Your Ref: A/23/15/OUT

Our Ref: NW/ARU/17/08D

RE : Land south of New Road (A259) and East of Brook Lane Angmering

Thank you for your correspondence of 22nd July 2018, advising me of a Hybrid application of a Full Planning Permission for a retail unit (Class A1) comprising 1,487sqm (1022sqm ground floor and 465sqm mezzanine) with associated access, Car parking, servicing, landscaping & associated works.

PROPOSED OFF-SITE FOOTPATH/CYCLEPATH LINK

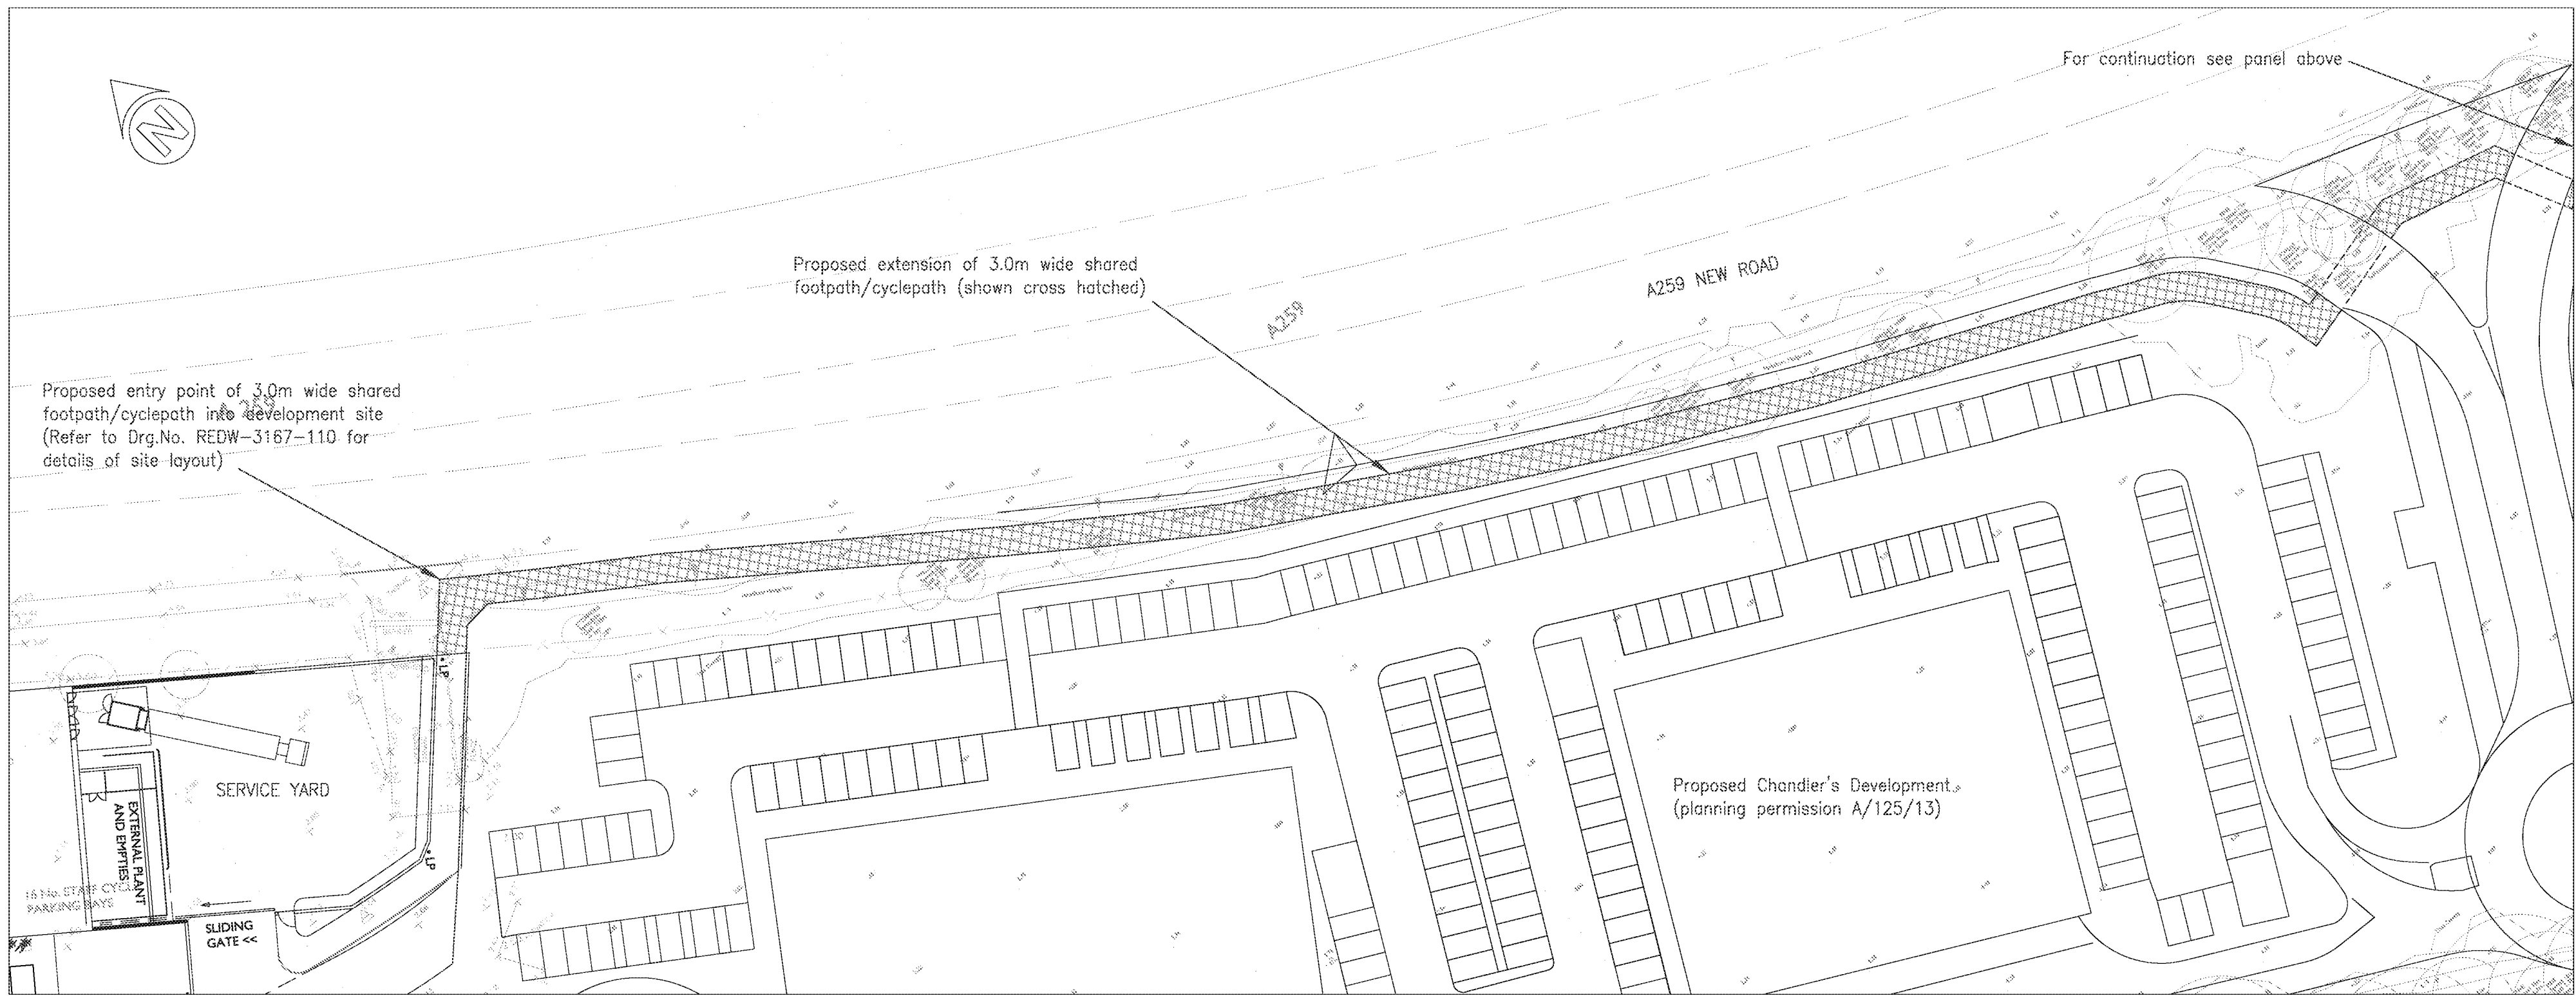
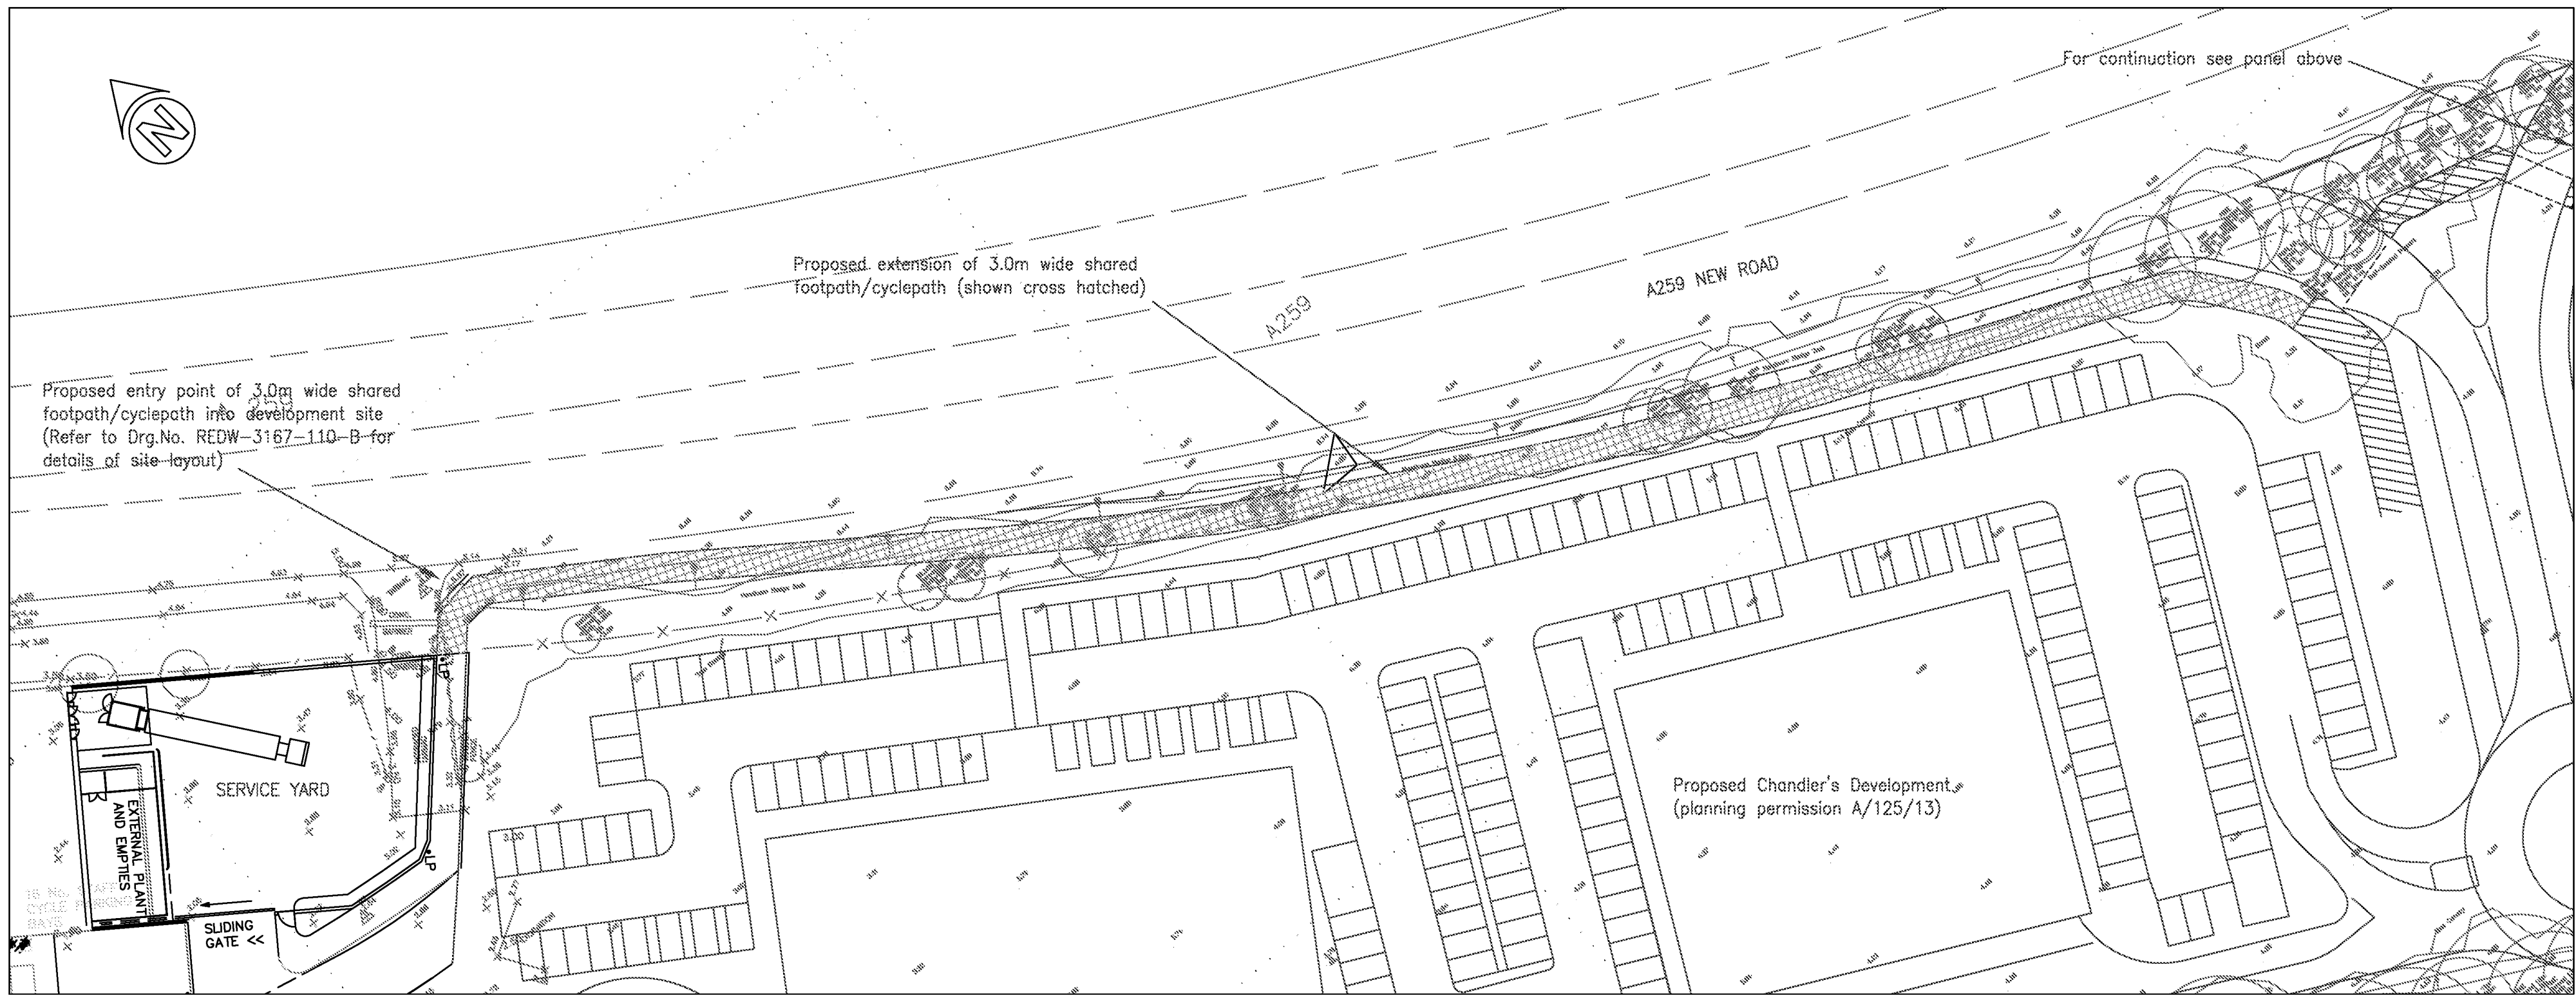
I was pleased to see that the footpath along the road frontage has been improved by providing a 3 metre wide shared footpath and cycle path, together with a 1.05 metre high pedestrian guard rail on the retaining wall and corrugated safety fence where required on the roadside edge.

Fencing with gated access should also be provided as a safety barrier between the public house and the retail unit on the northern perimeter of the car park to separate the A259 road and car park areas, to prevent persons from easily straying onto the road. (Especially children).

Although pedestrian numbers may be low and although currently well signposted with warning signs on the approach from the east, I also have concerns regarding a safe area for pedestrians or cyclists who wait at the exit lane of the development, and wish to cross the A259 from the Brook Lane and exit road, to the footpath on the north side of the A259. (The shortest and most direct route across). A possible desire line may be to wait at the edge of the west side of the acceleration lane opposite the footpath on the north side of the A259. This will mean pedestrians will be crossing three lanes of traffic to reach the central reservation. Drivers leaving the application may well be looking in their rear view mirrors as they join the main carriageway and be less aware of persons about to cross ahead of them.
